November 23, 2022

Jay B. Rodenbeck
Senior Planner
City of Albuquerque
Development Services, Planning Department
1 Civic Plaza N.W.
Albuquerque, NM 87102

RE: Responses to Comments
Costco Fuel Facility – On-Site Relocation
1420 Renaissance Boulevard, Albuquerque, New Mexico 87107
Costco Loc. No. 116 / Our Job No. 10896

PRELIMINARY LANDSCAPE PLAN

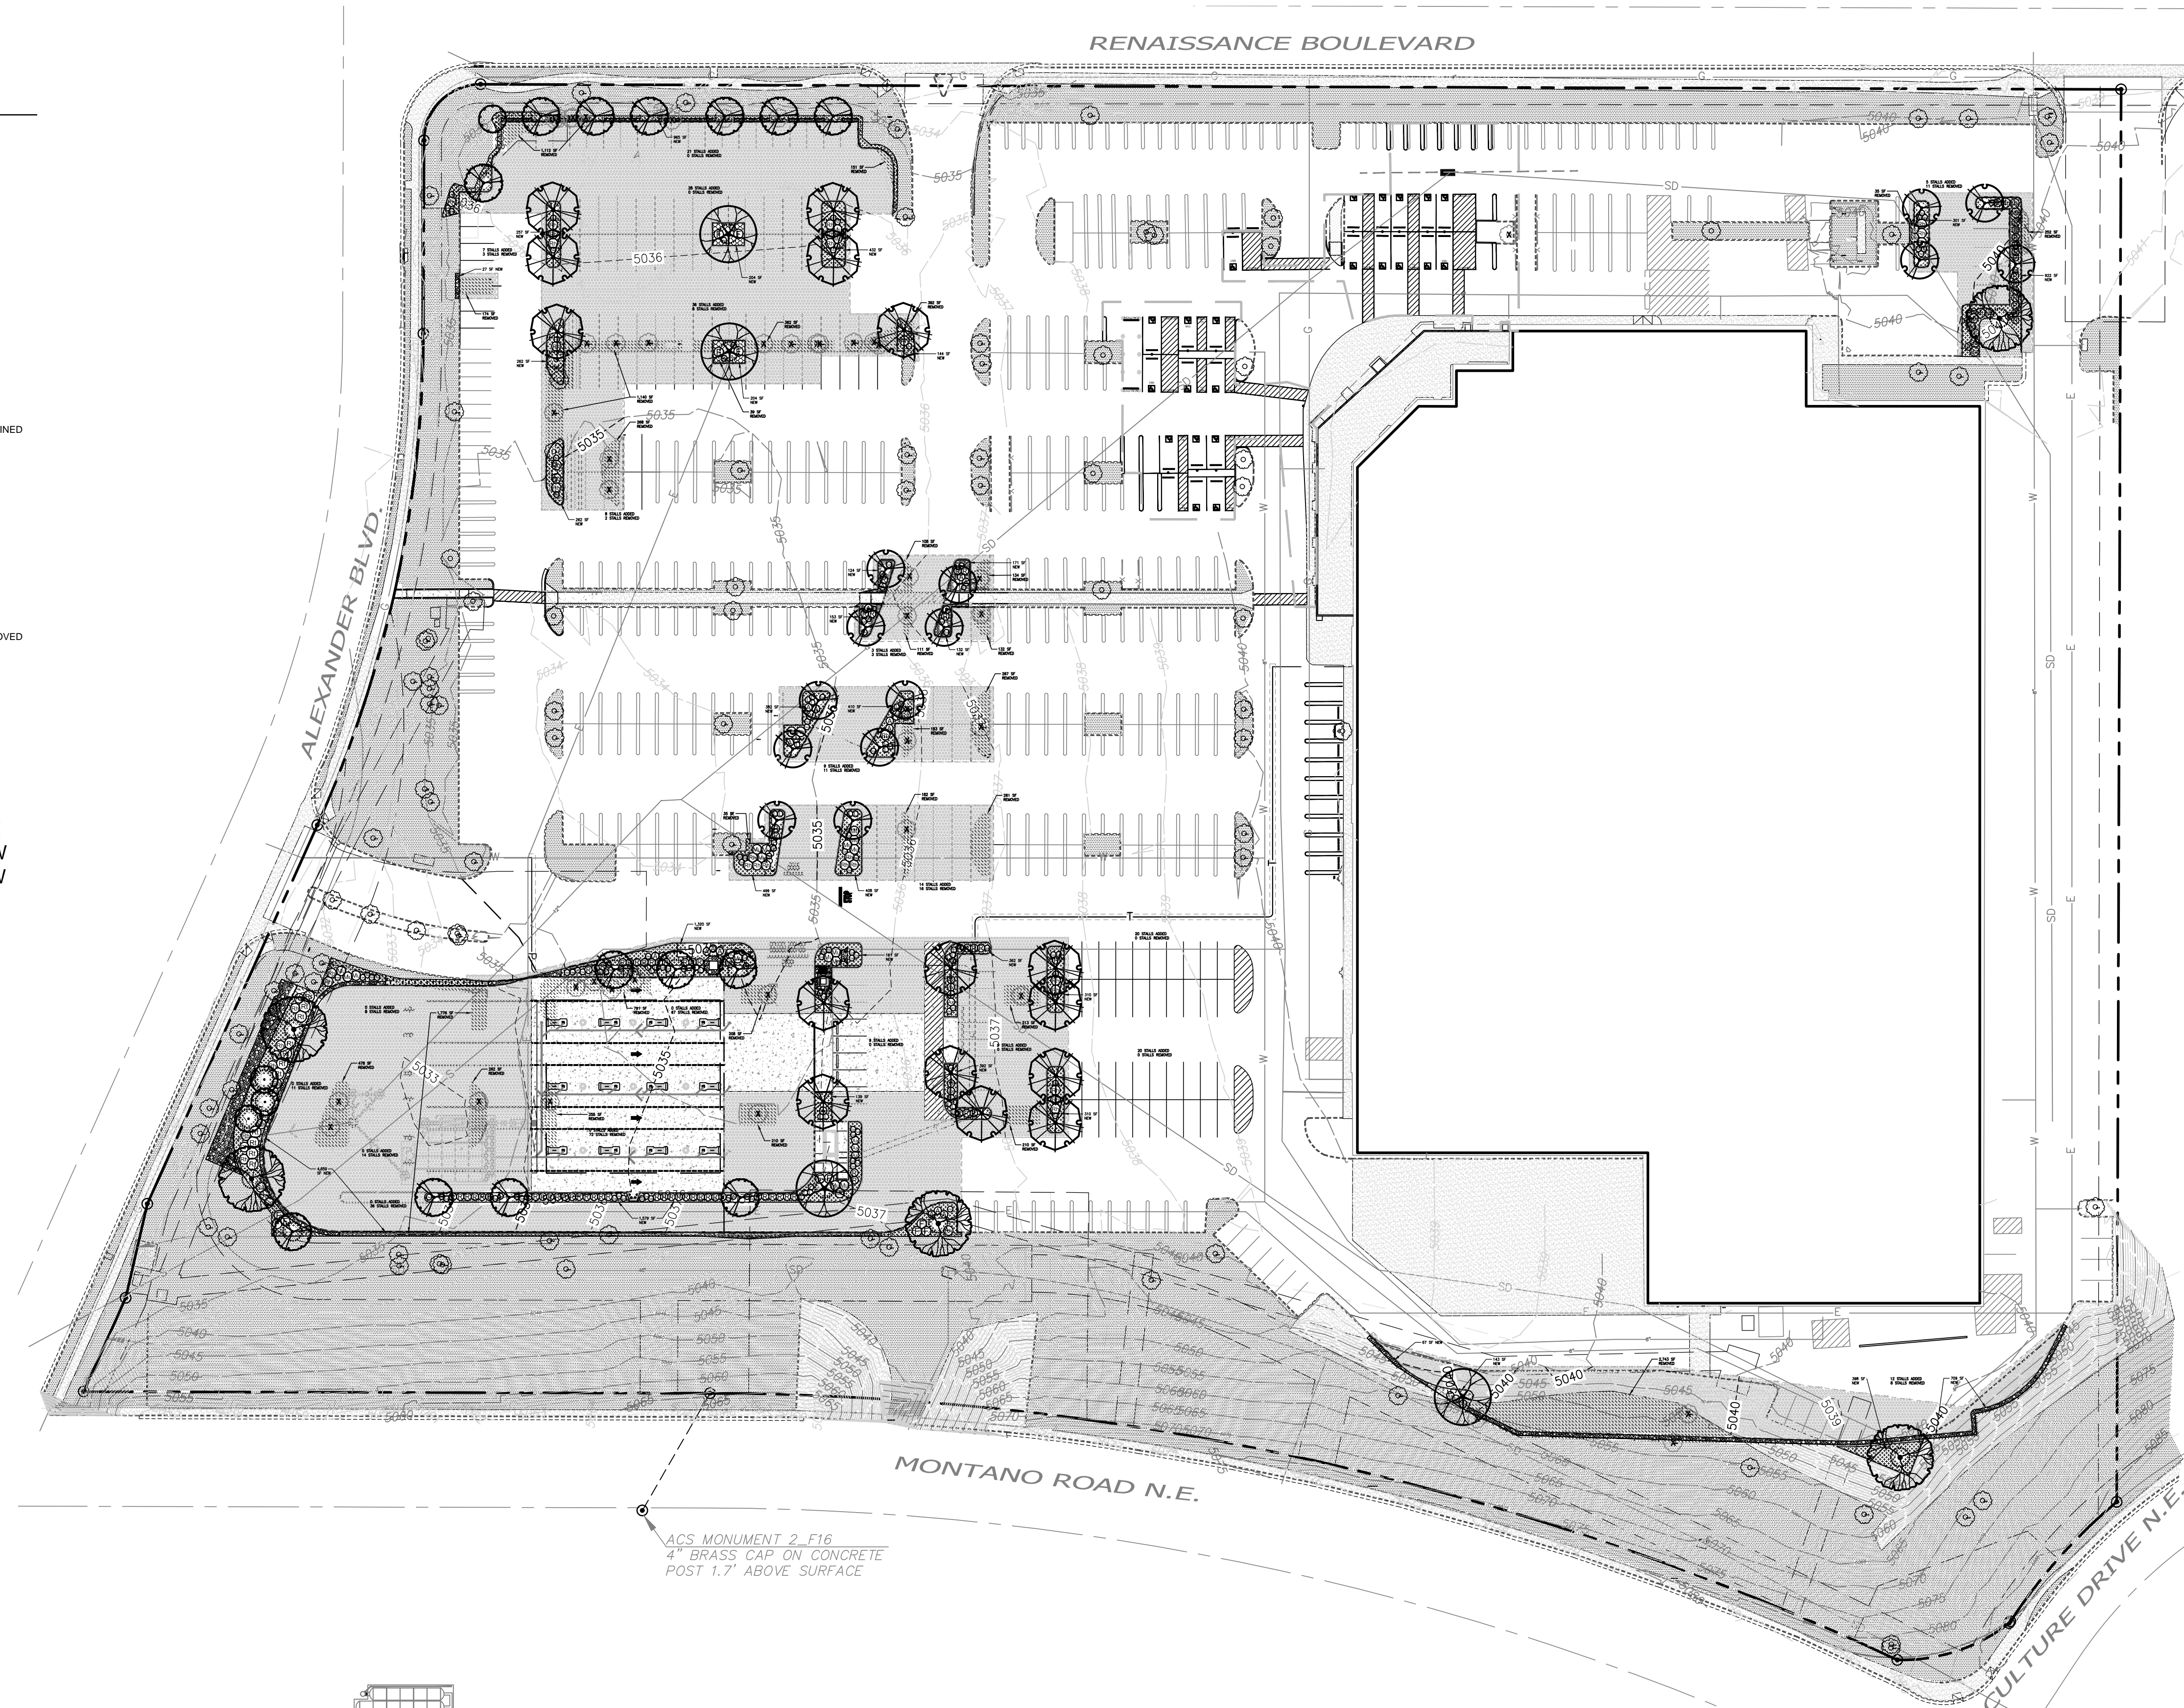
- *Are you able to provide the entire landscaping plan on one sheet? Please show compliance with the ‘minimum landscape area’ of 15% of the net lot area per IDO 5-6(C)(2). An earlier email invited you to meet with the Balloon Landing Task Force. Alterations to landscaping related to that meeting could be considered.*

Response: The preliminary landscape plan included in this supplemental submittal has been updated to include Sheet L1 with the overall view.

# OVERALL SITE PLAN

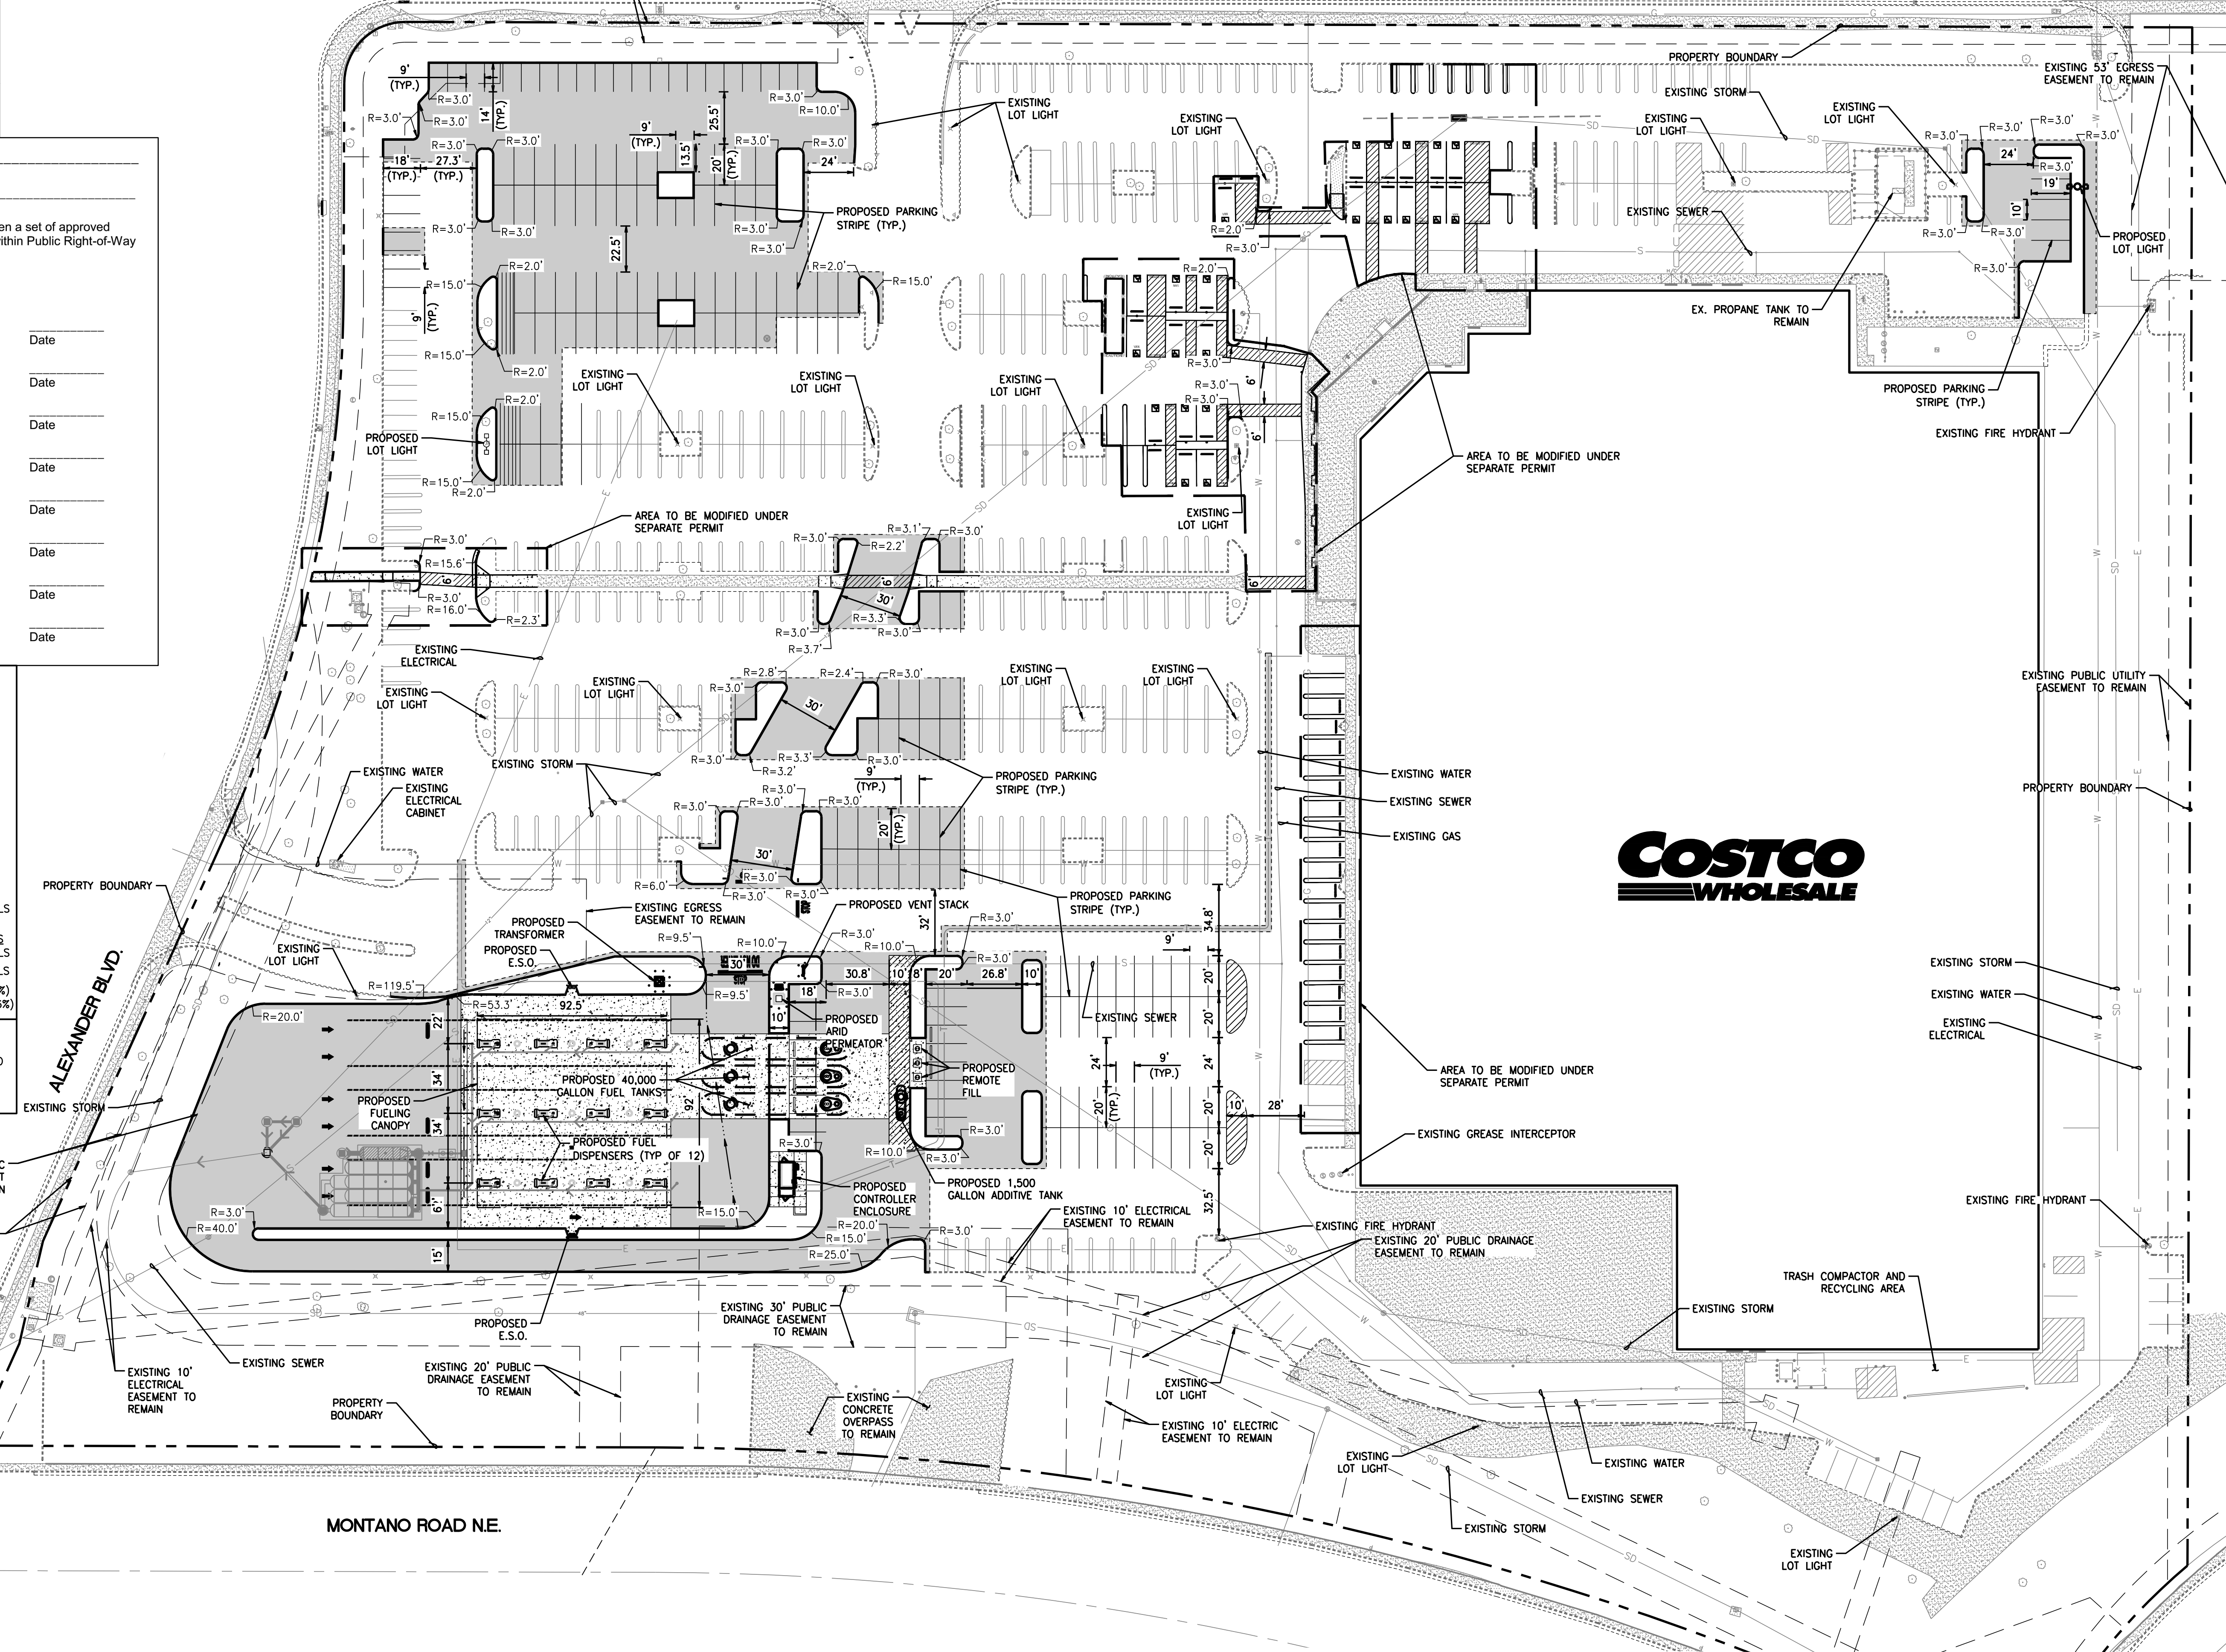
- *Add signature blocks for DRB signatures, the Environmental Health signature, and the Solid Waste signature to the Site Plan Amendment.*

- *The Environmental Health Department has confirmed that this project will be regulated by the State of NM Environment Department and the Air Quality group of the Environmental Health Department. A note must be added to the Site Plan as follows: "This project will be regulated by the State of NM Environment Department and the Air Quality group of the Environmental Health Department for the City of Albuquerque."*

- *Are you able to provide a sheet of the entire main site layout on one sheet? Please provide required parking and provided parking calculations for the new site layout. (See IDO Table 5-5-1.) See IDO 5-5 for complete parking requirements and design.*

- *I did not see the plans showing all the parking dimensions and radii that we had worked on together. I need this to be part of the official file. No objections so long as this is in the file.*

Response: A Signature Block for DRB has been added on the Overall Site Plan included in the supplemental submittal, as requested.

Response: The above referenced note has been added to the Overall Site Plan included in the supplemental submittal.

Response: The overall site plan included in this supplemental submittal has been updated to include a Project Data table containing all requested site information with the main layout on one sheet.

Response: The overall site plan included in this supplemental submittal contains the parking dimensions and radii previously discussed.
